Ann Machado - Re: Permit #2014-00621 - 38 Smith Street

From: Greg Scott <gscott207@gmail.com>
To: Ann Machado <AMACHADO@portlandmaine.gov>
Date: 4/14/2014 3:46 PM
Subject: Re: Permit #2014-00621 - 38 Smith Street
CC: Gerry Dauphin <gerry_dauphin@hotmail.com>
Attachments: 38 SMITH STREET SITE SKETCH.pdf

EXG. BASEMENT PLAN
 SCALE: 1/4" = 1'-0"

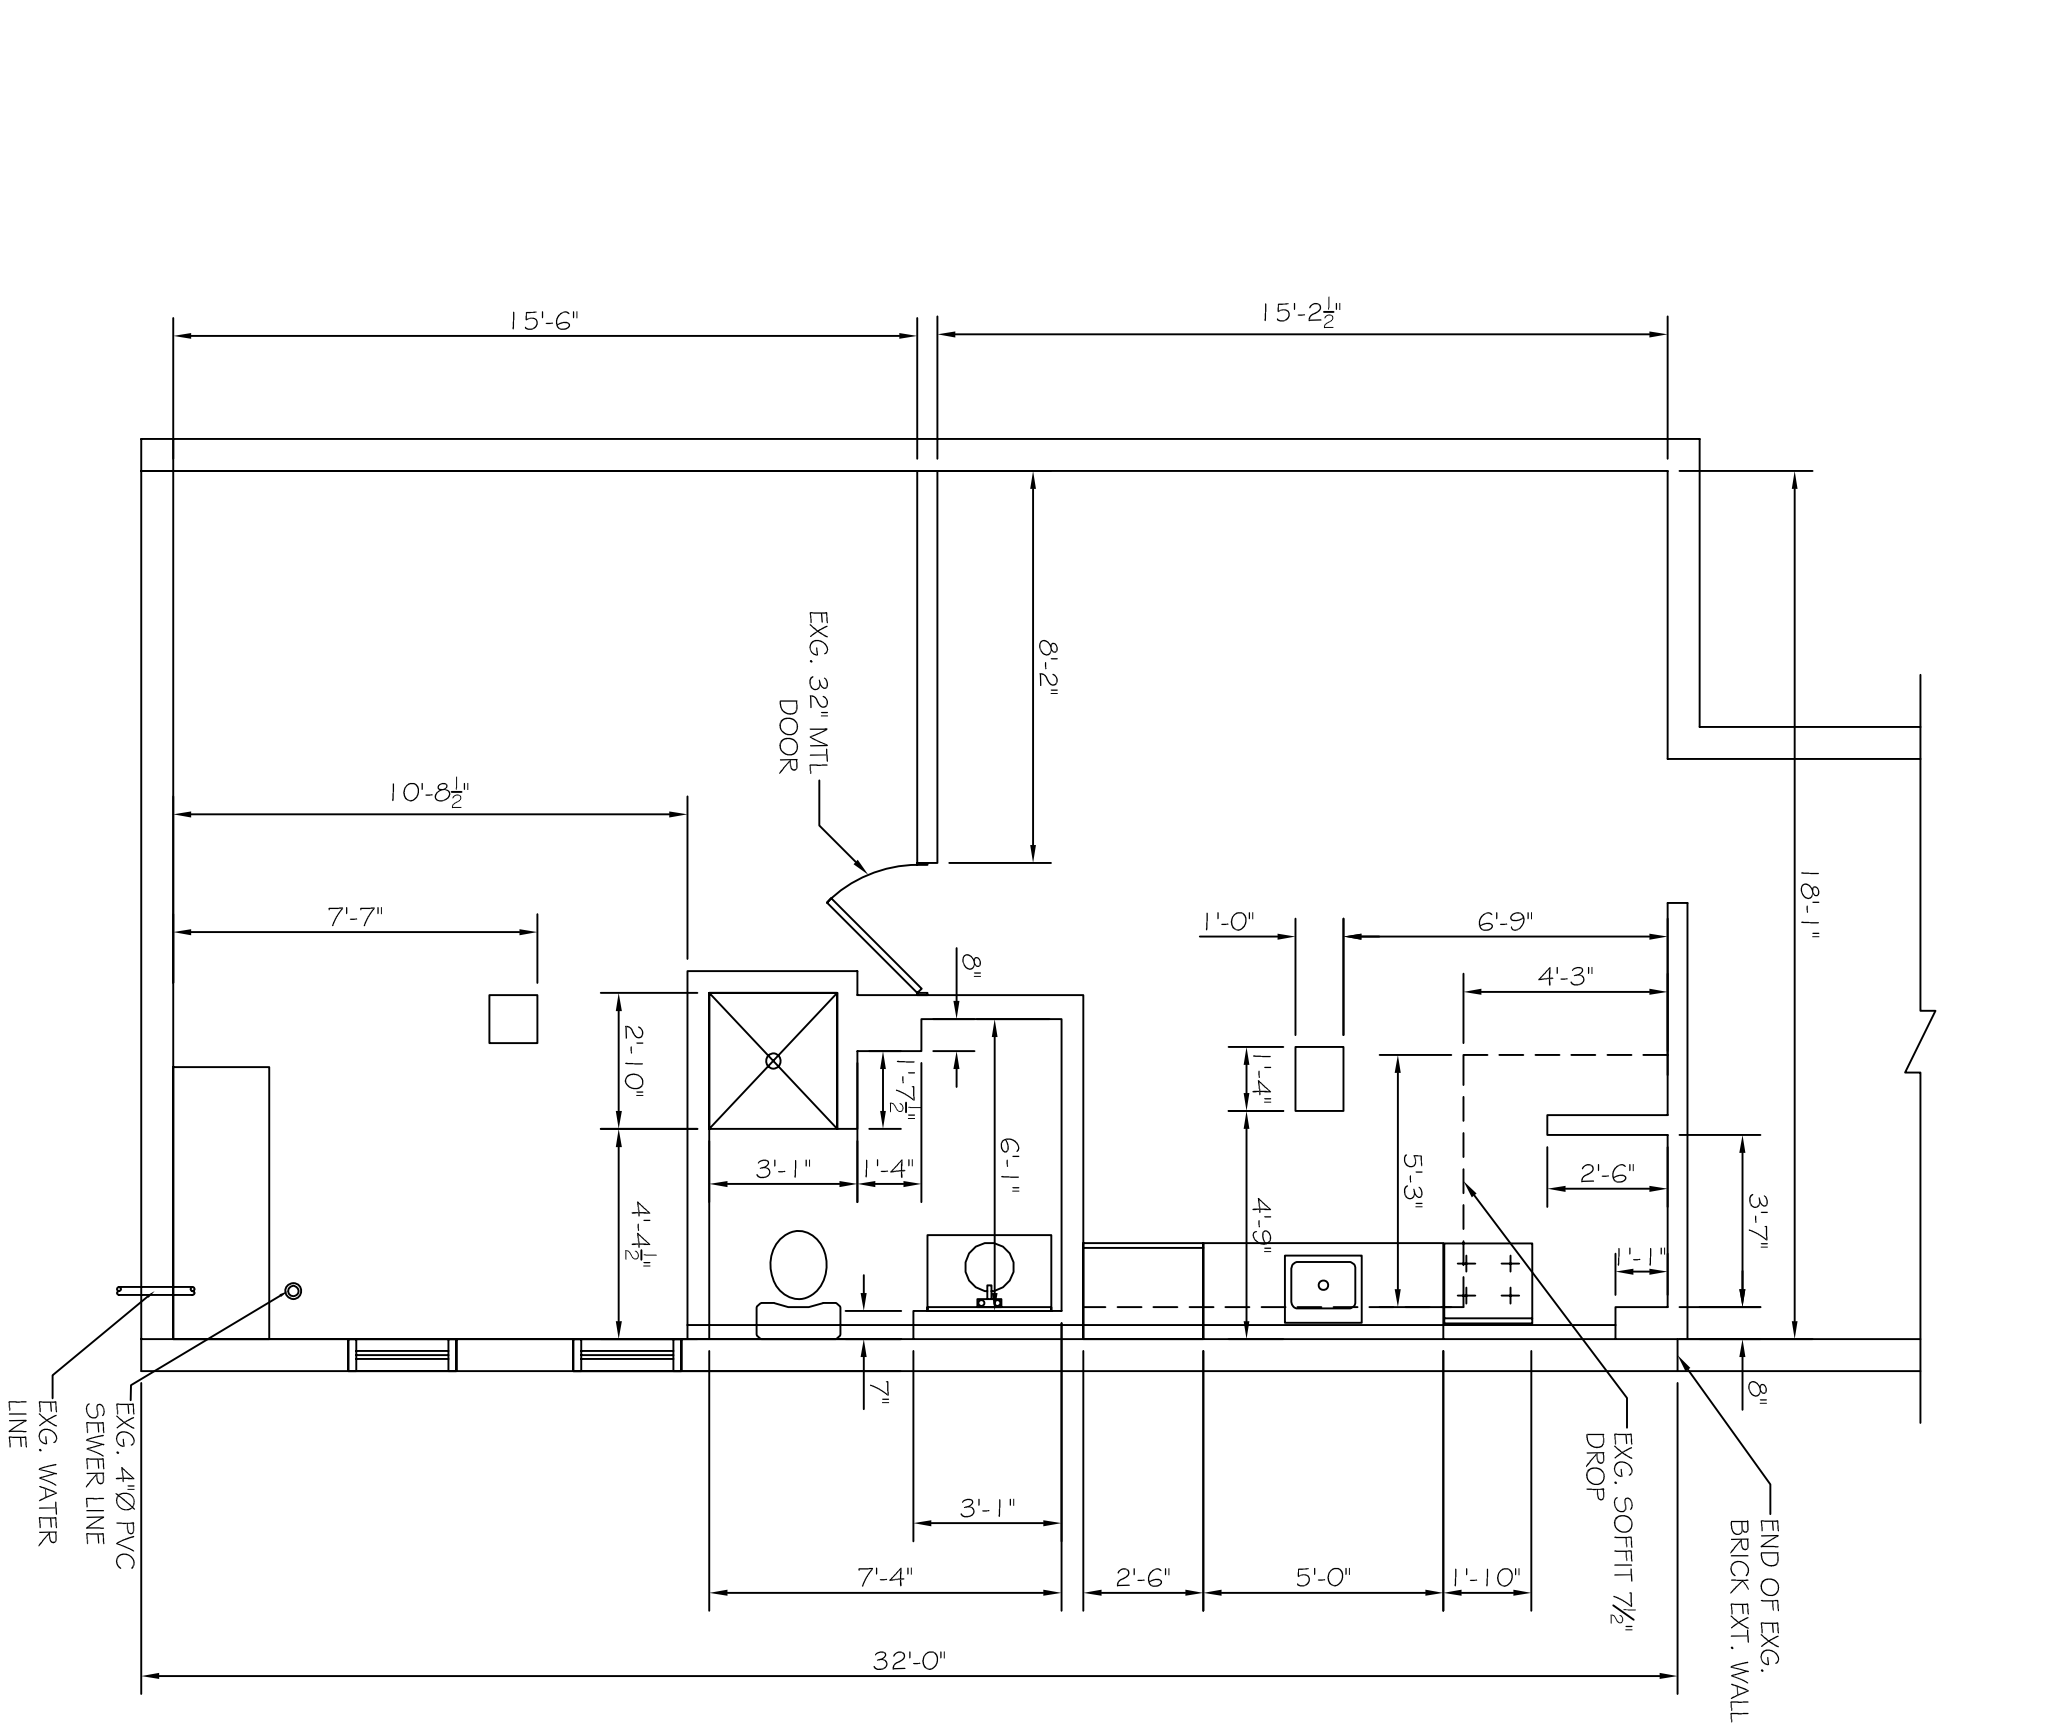
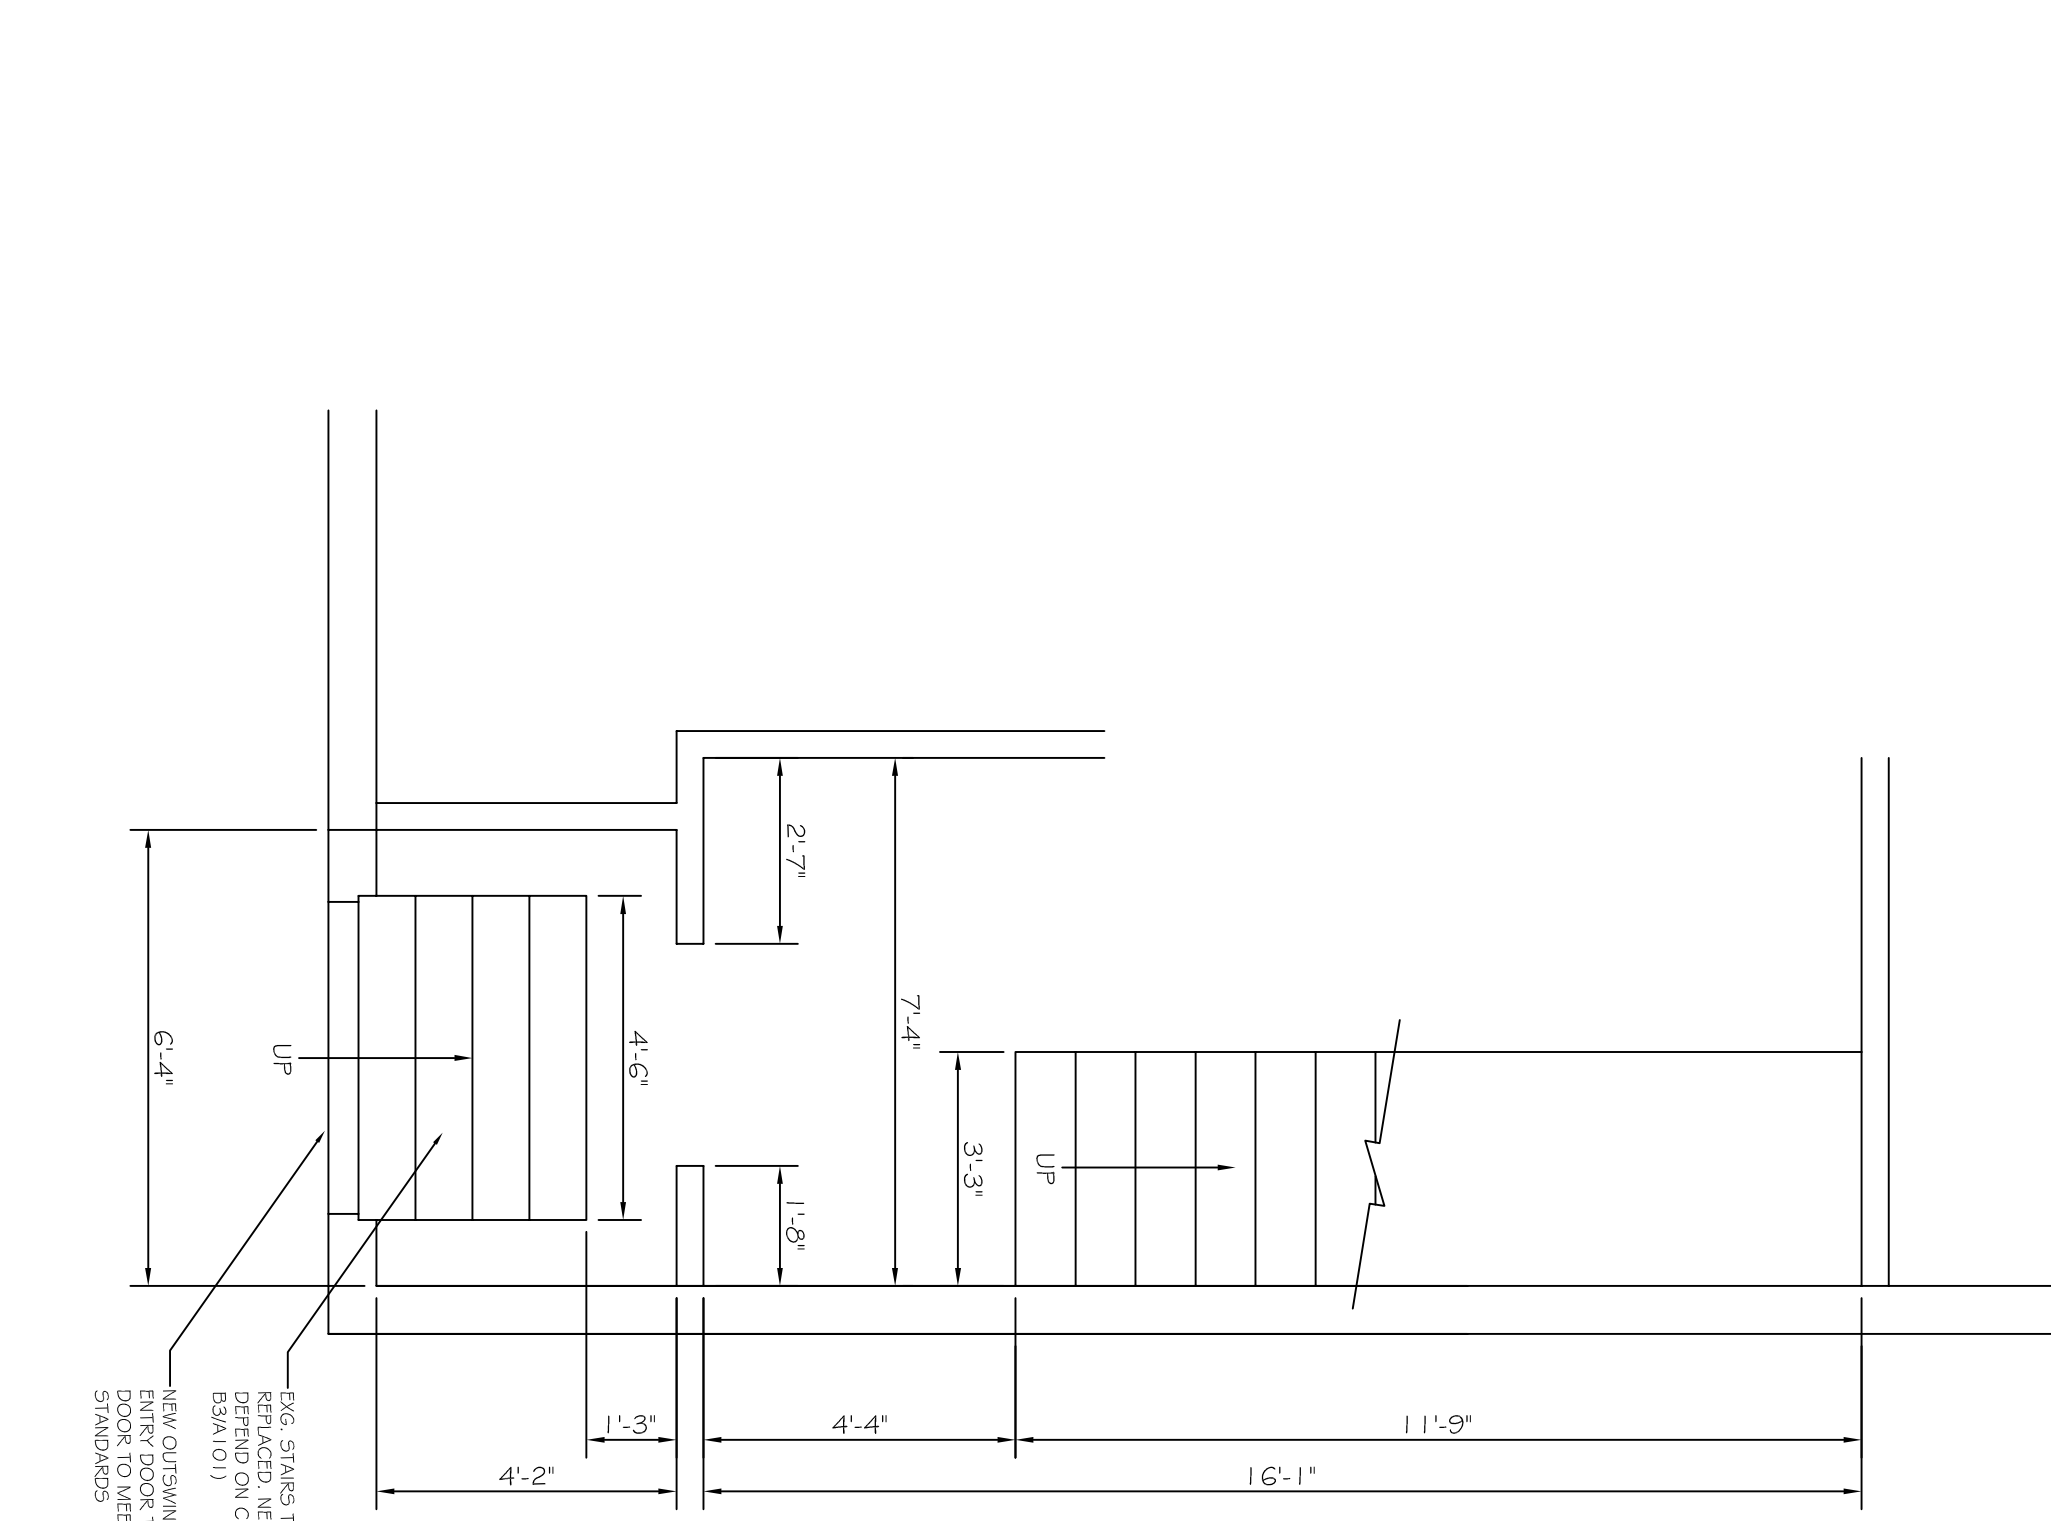
I assume that A3 & A4 are the floor plan for the basement.

Section 14-136(a)(2)(e) states that a below grade dwelling unit is only permitted if access is provided directly to the outside. Is more than half of this unit below the average grade? If so you need to provide access directly to the outside.

A3 & A4 are floor plans of the basement. See A3 & A4 the existing exterior door directly to the exterior is located off the living room to the driveway. Less than half off the basement is below grade.
